From:
Sent: 07 September 2024 12:59
To: DC Admin
Subject: App no: 2024/91236 - objection

This is to state our objection to this latest amendment, application number 2024/91236, to the previous permission 2020/93954 for erection of 42 dwellings and associated works.

Project :	Housing at Lingards Road, Slaithwaite.		
Client :	SB Homes.		
Drawing :	Plot 23 - Alternative layouts with garage.		
Scale :	1:100.	Date :	Nov 2023
Dwg No :	2019 572 Sk 13	Rev :	K

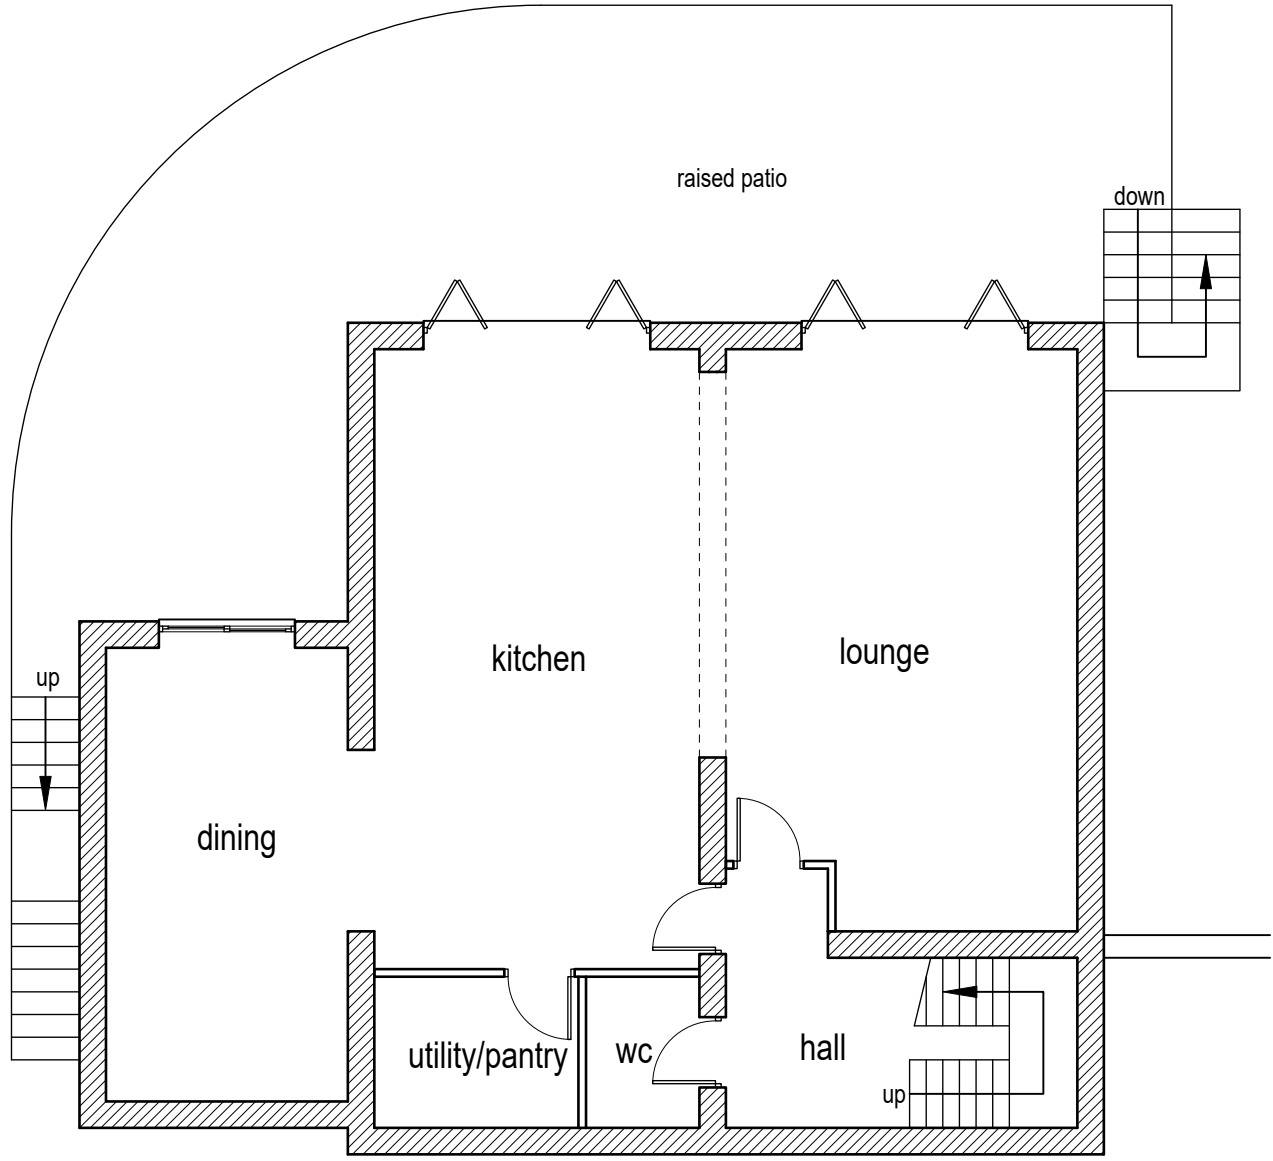
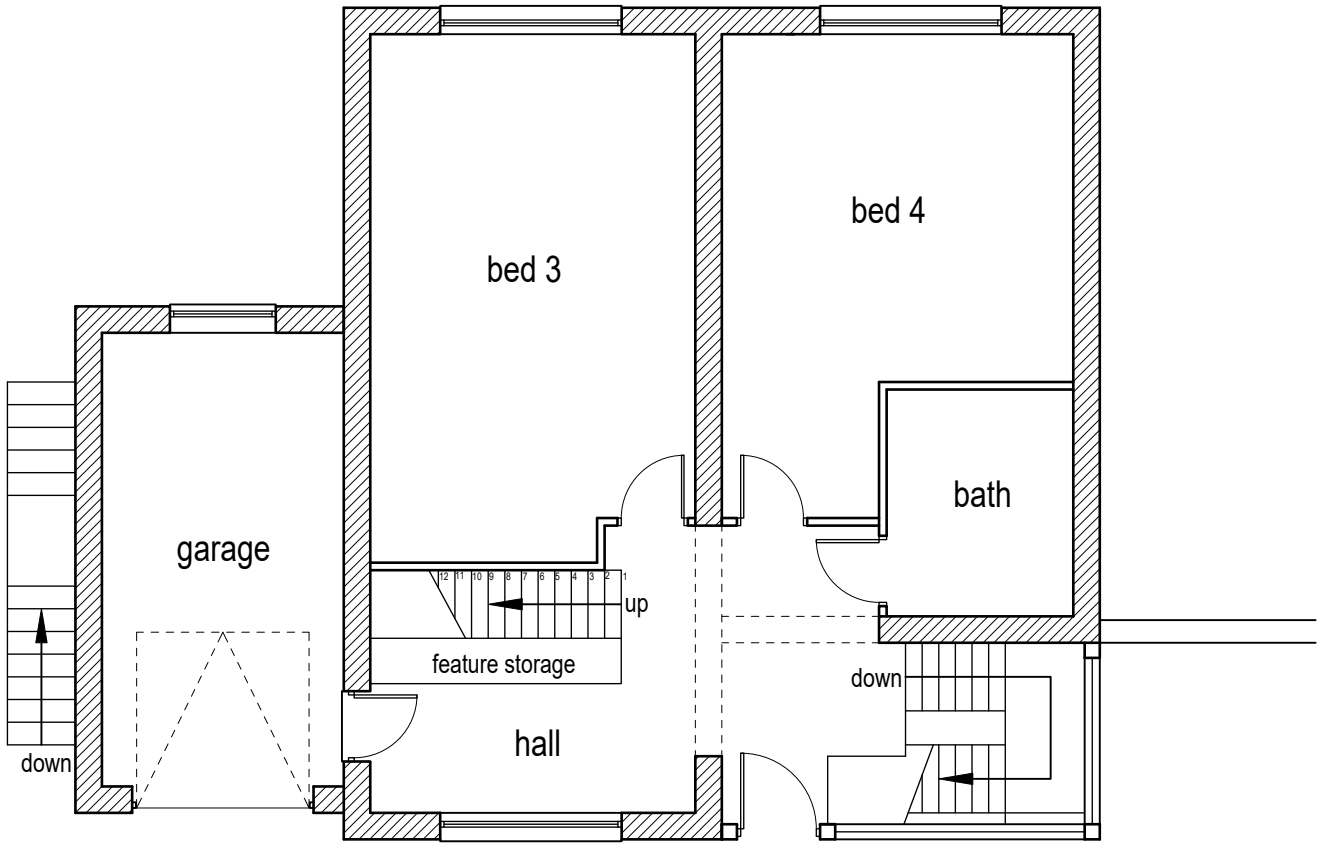
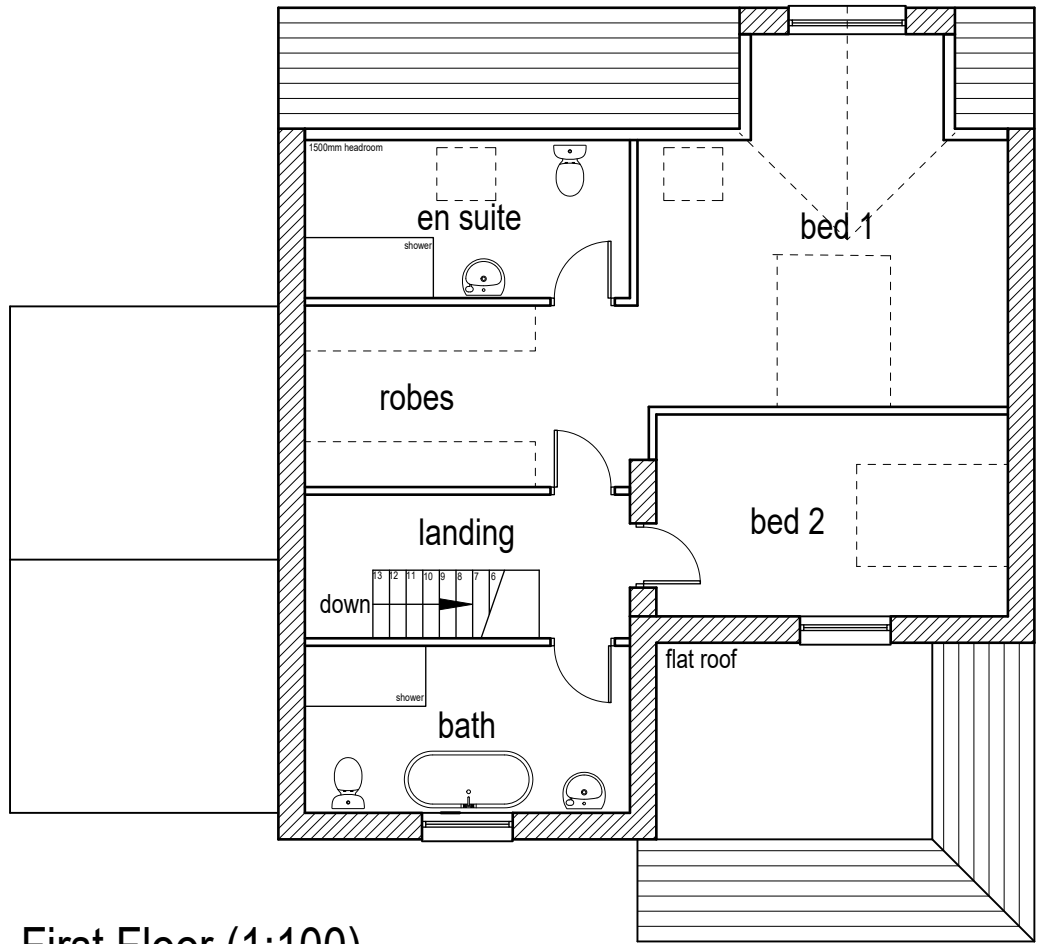
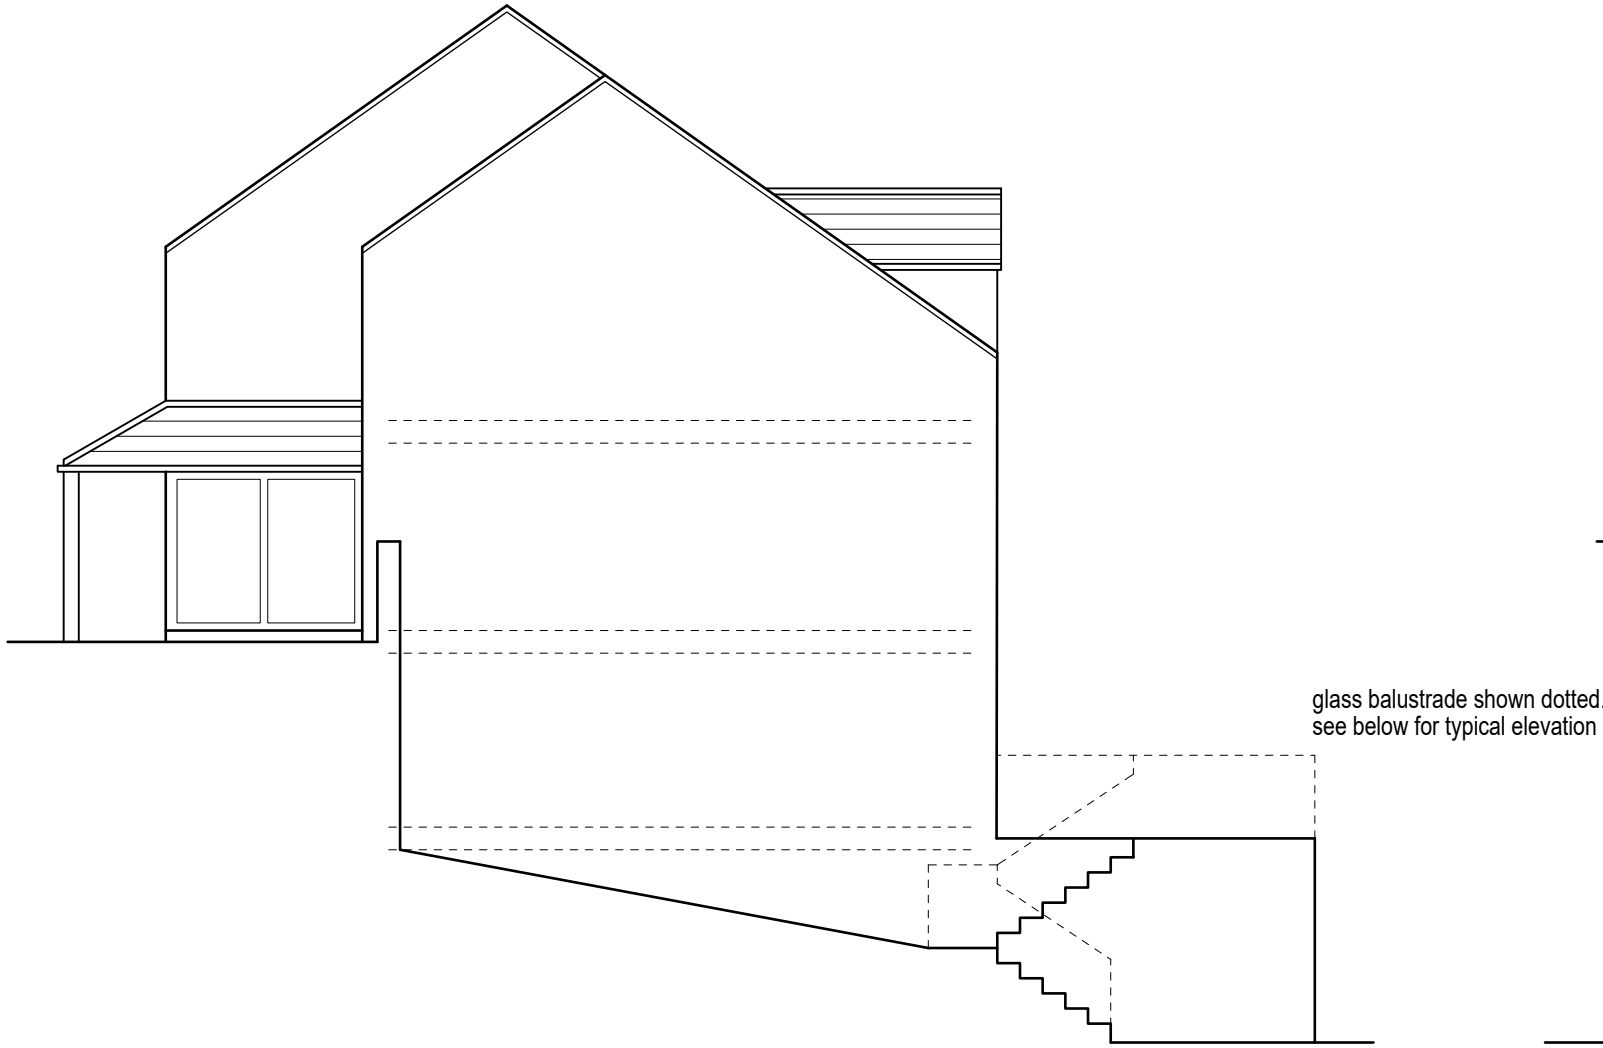
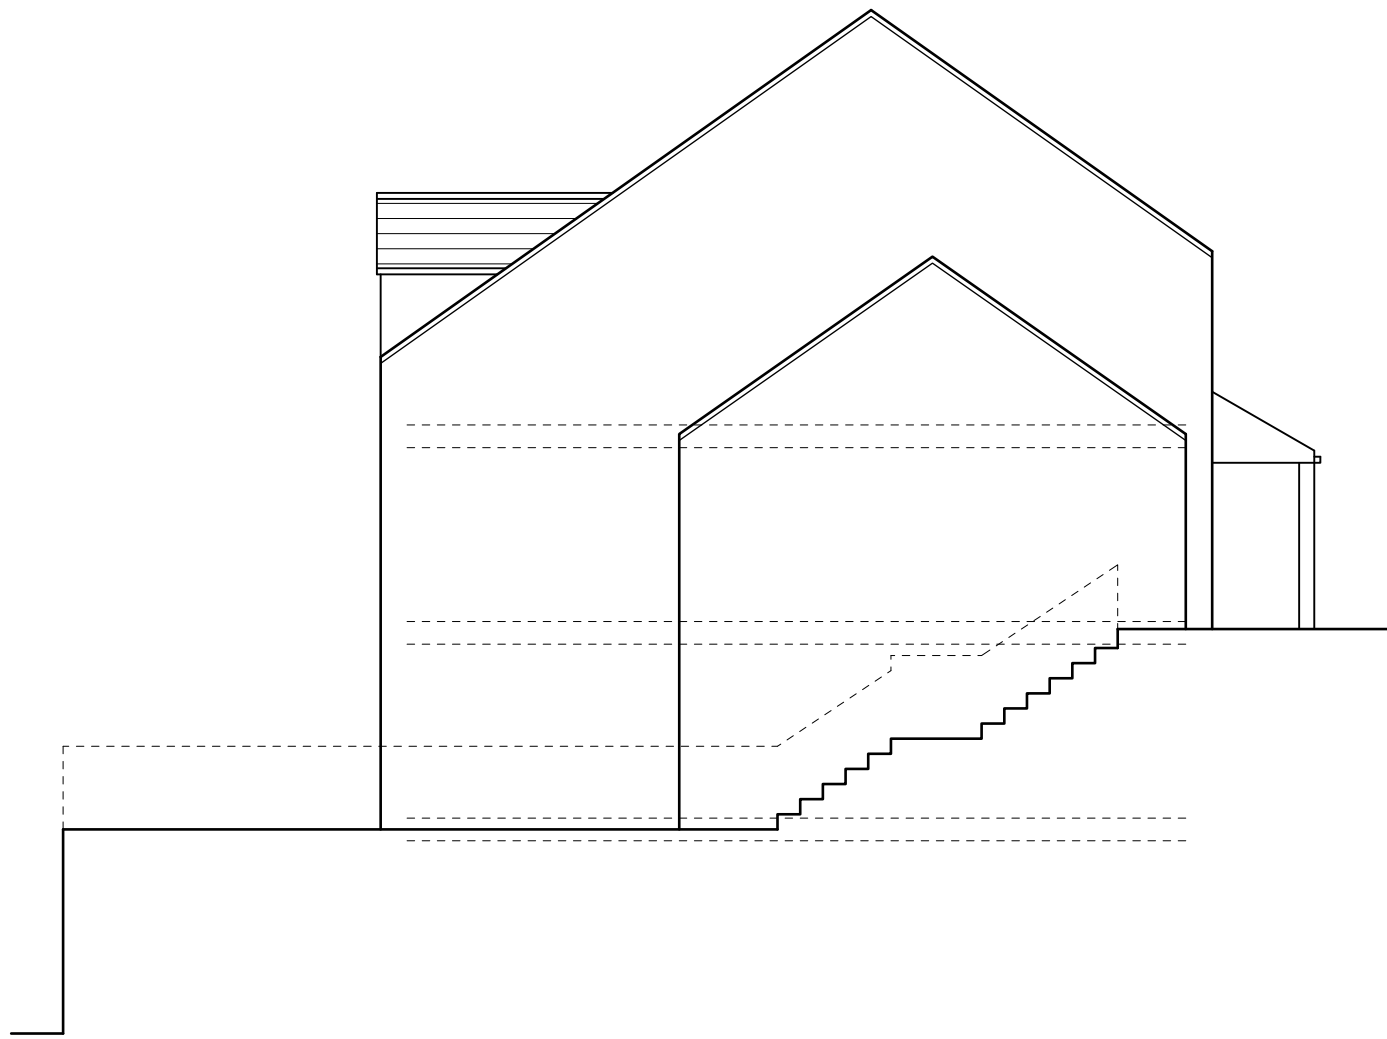
1. We object to the addition of a car port to the plans - this reduces the acceptable distance from the proposed house to our property (plot 35).
2. The latest application also includes a basement, making the houses 4-storeys and out-of-keeping with all of the existing homes in the surrounding area.
3. The two proposed homes (plot 34 & 35 I believe) would be at least a two-and-a-half storeys high on Lingards Road, all living space.
4. A stop notice has been issued to the developer as he has contravened existing agreements made as part of the planning permission.
5. The developer should be made to lay out all the variations to the original planning application that was approved in one go so residents can assess the impact as a whole.
